CUMBERLAND
CITY COUNCIL

Our Ref: OA2021/0005
DPIE Ref: SSD-10399

Subject: Request for Comments - State Significant Development (SSD)
Application No: SSD-10399
Property: 44 Clunies Ross Street & Great Western Highway, PROSPECT NSW 2145
615A Great Western Highway & Boral House – Clunies Ross Street,
PEMWULWUY NSW 2145
Proposal: Proposed warehouse and logistics estate at Clunies Ross Street,
Pemulwuy

DRAWING TITLE
Landscape Concept Plan 01

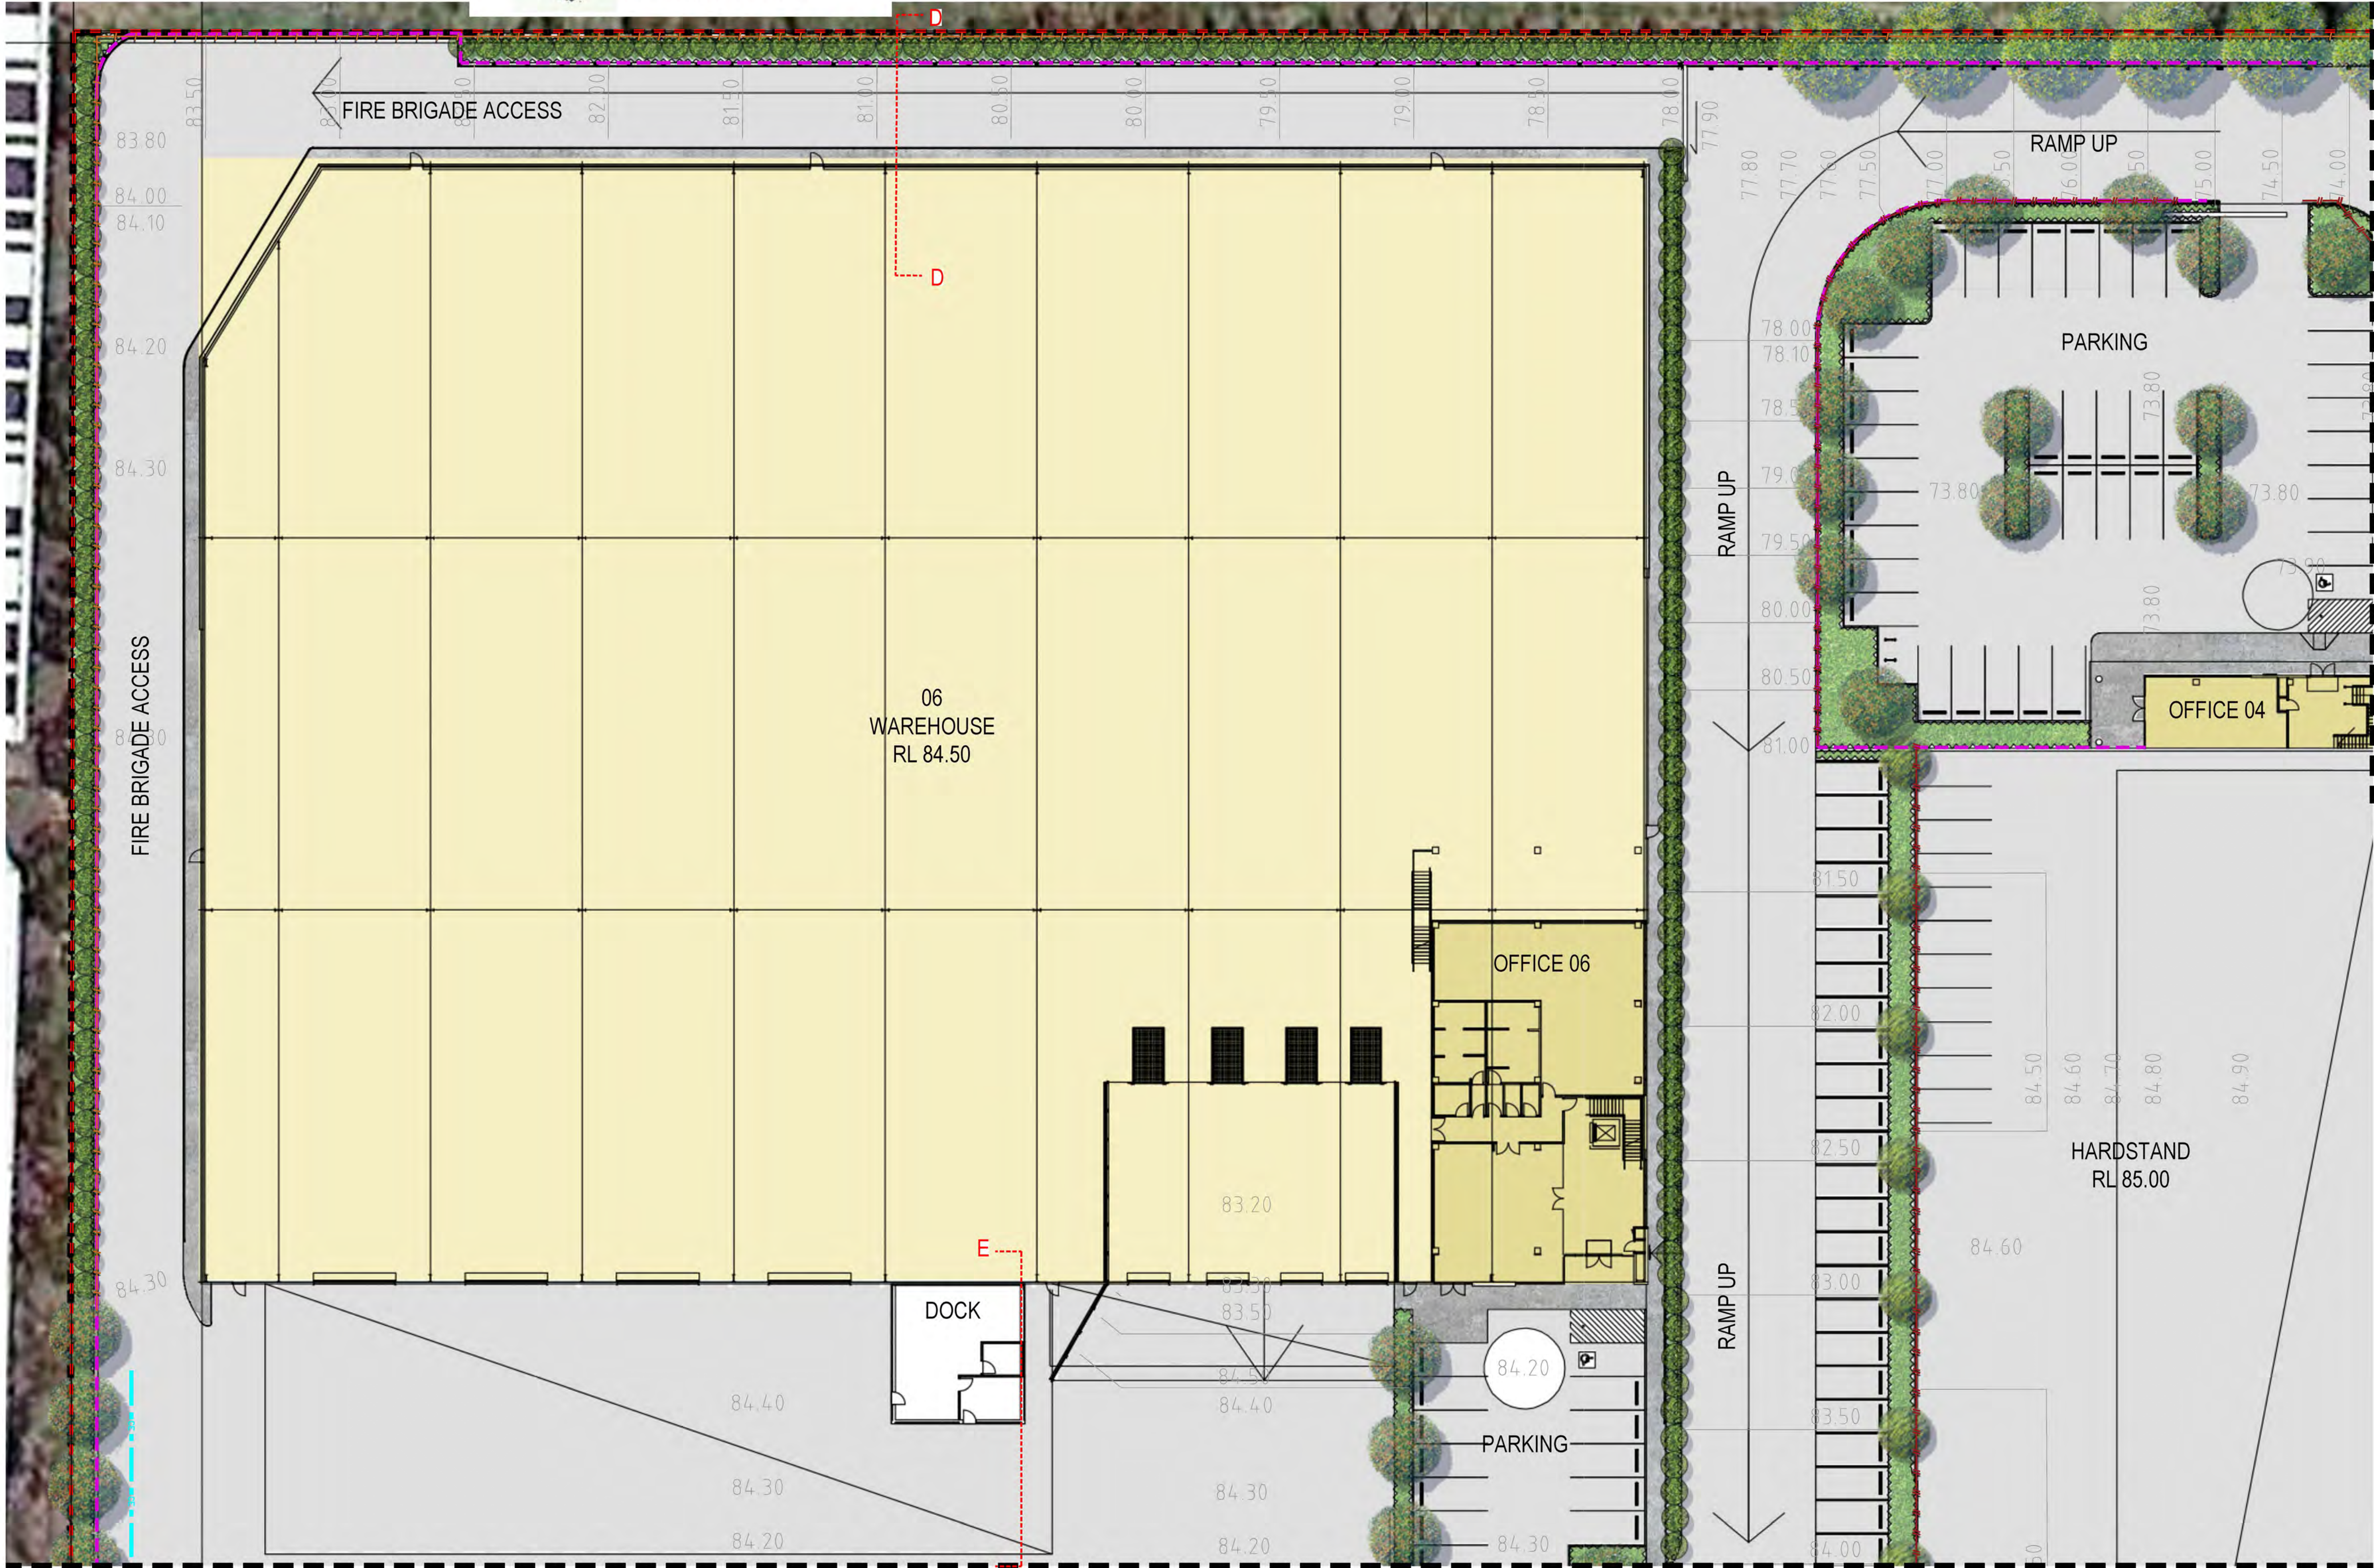
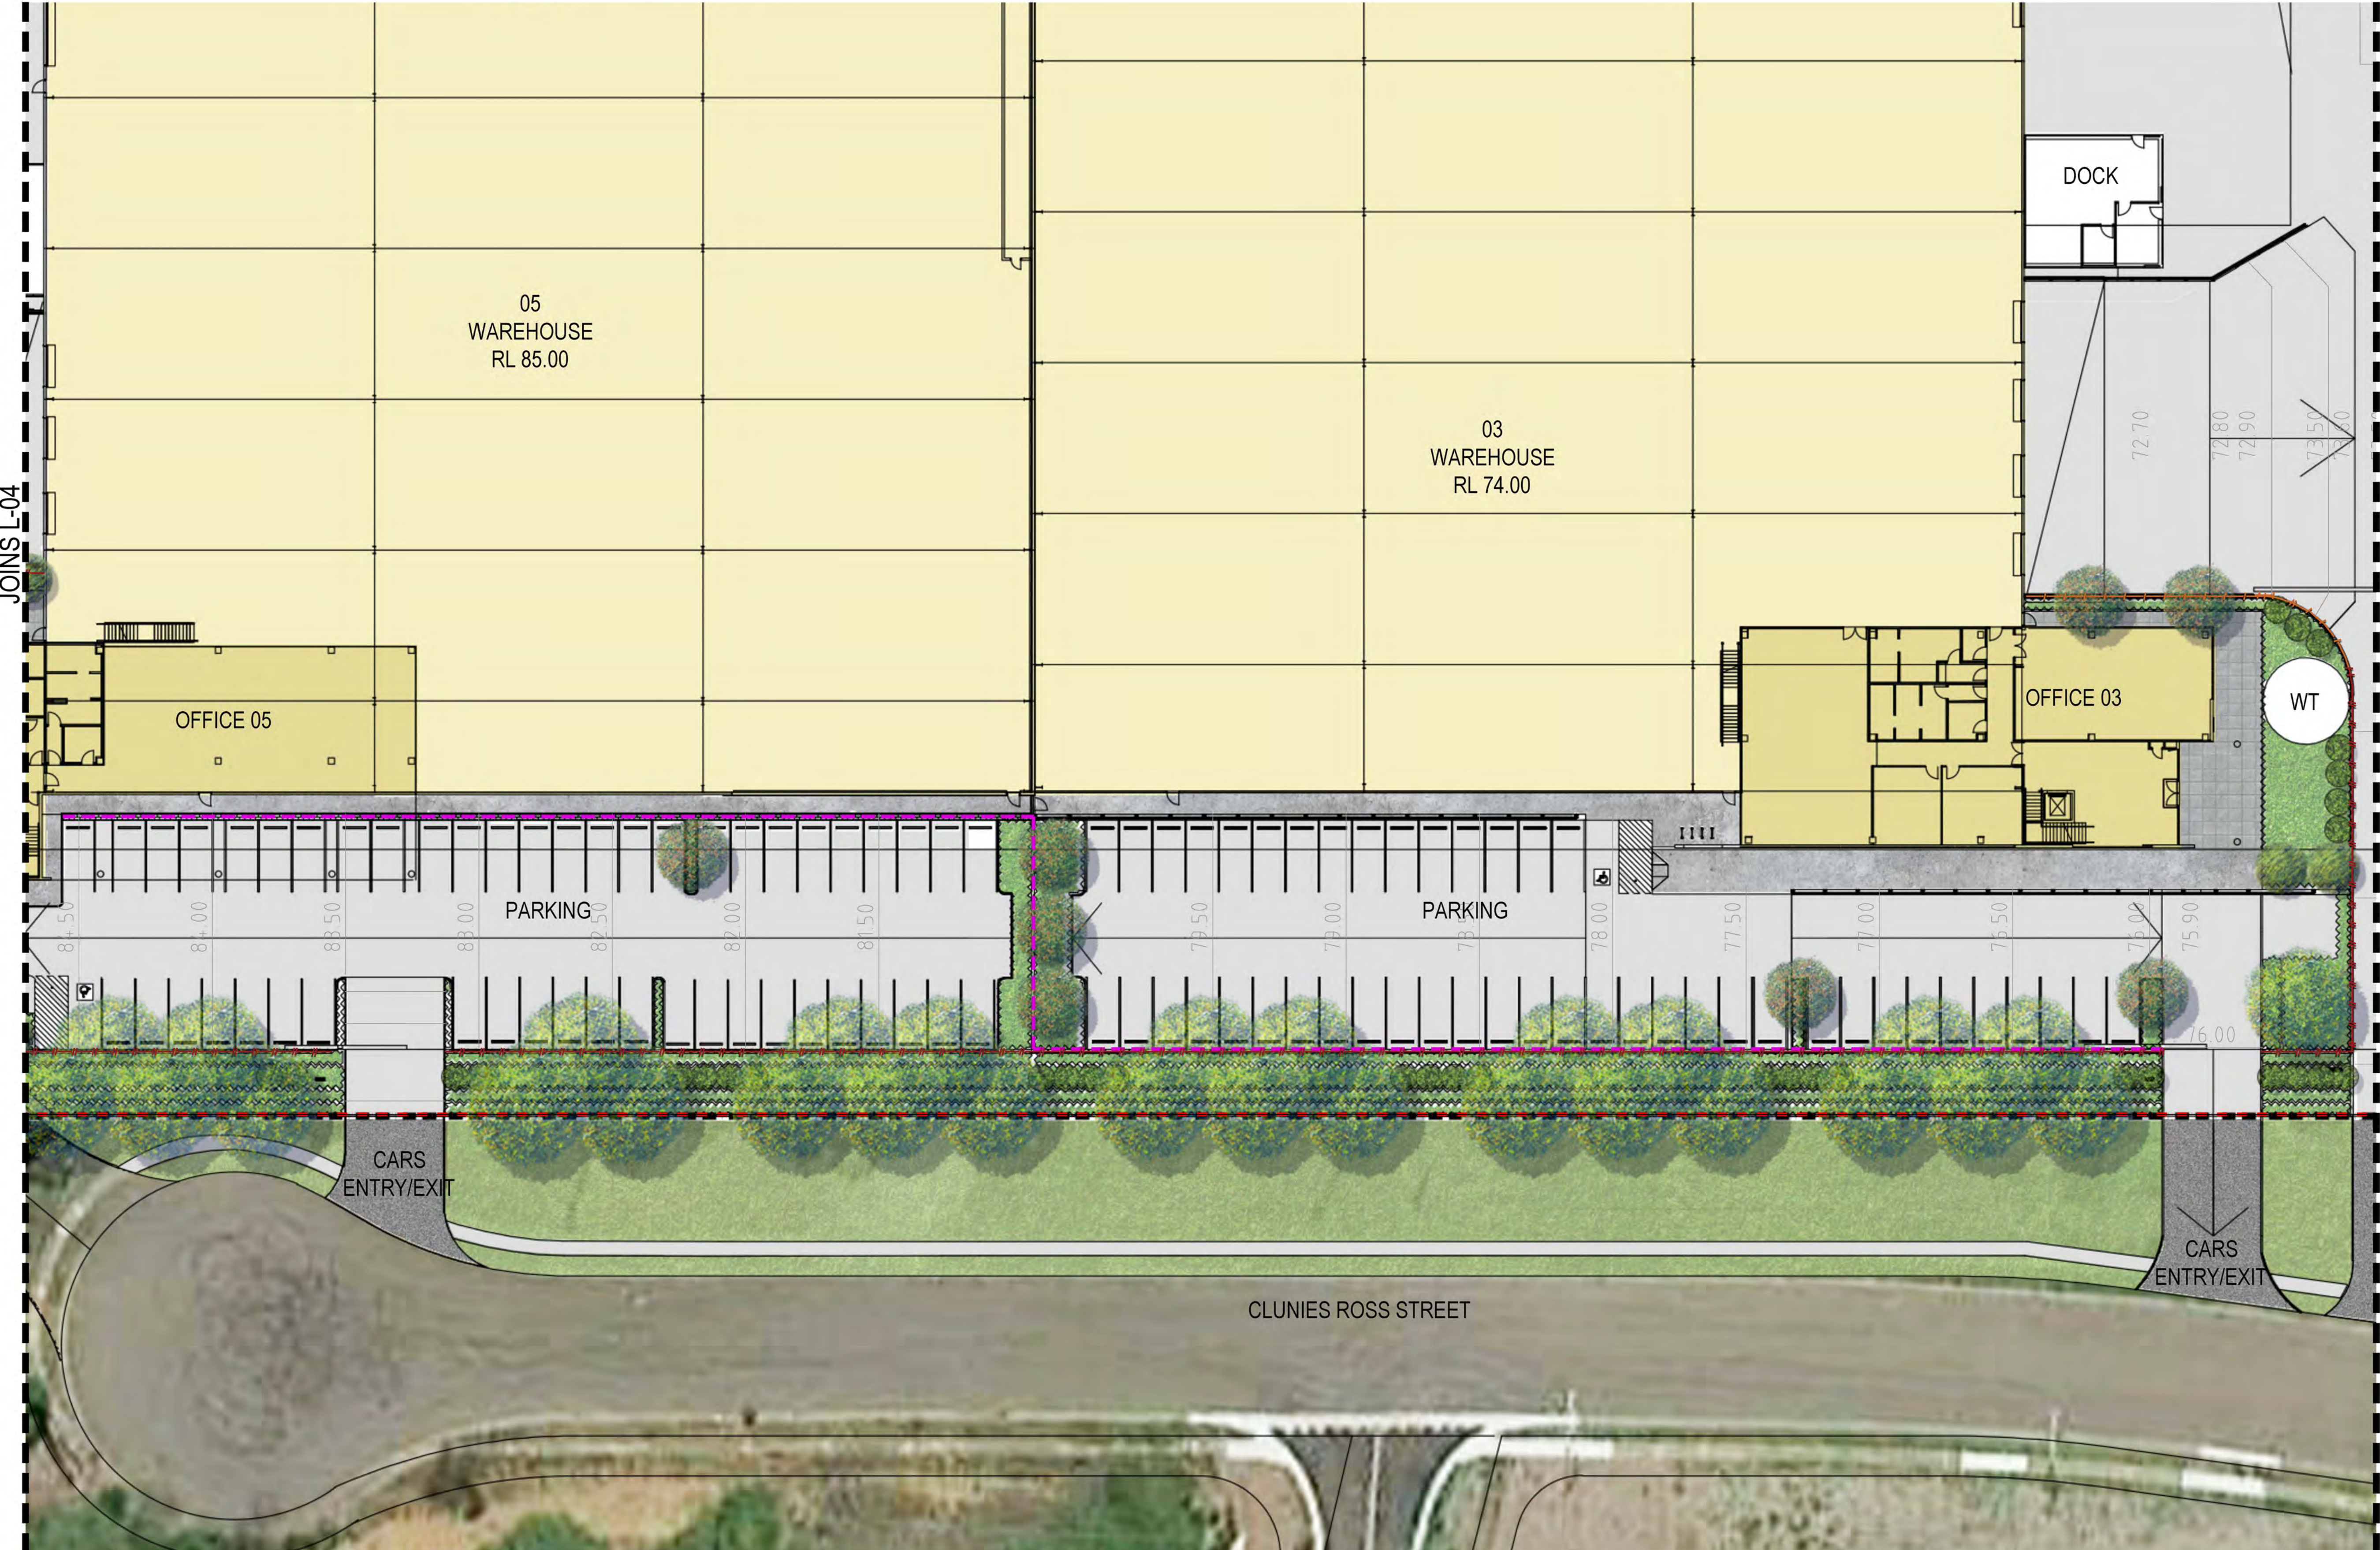
12. No detailed landscape plans have been submitted. Clarification is required in relation to the finished streetscape landscaping proposed along Clunies Ross Street and the treatments along the rear boundary perimeters especially the creek line areas, whether they will be revegetated with CPW Species, etc.
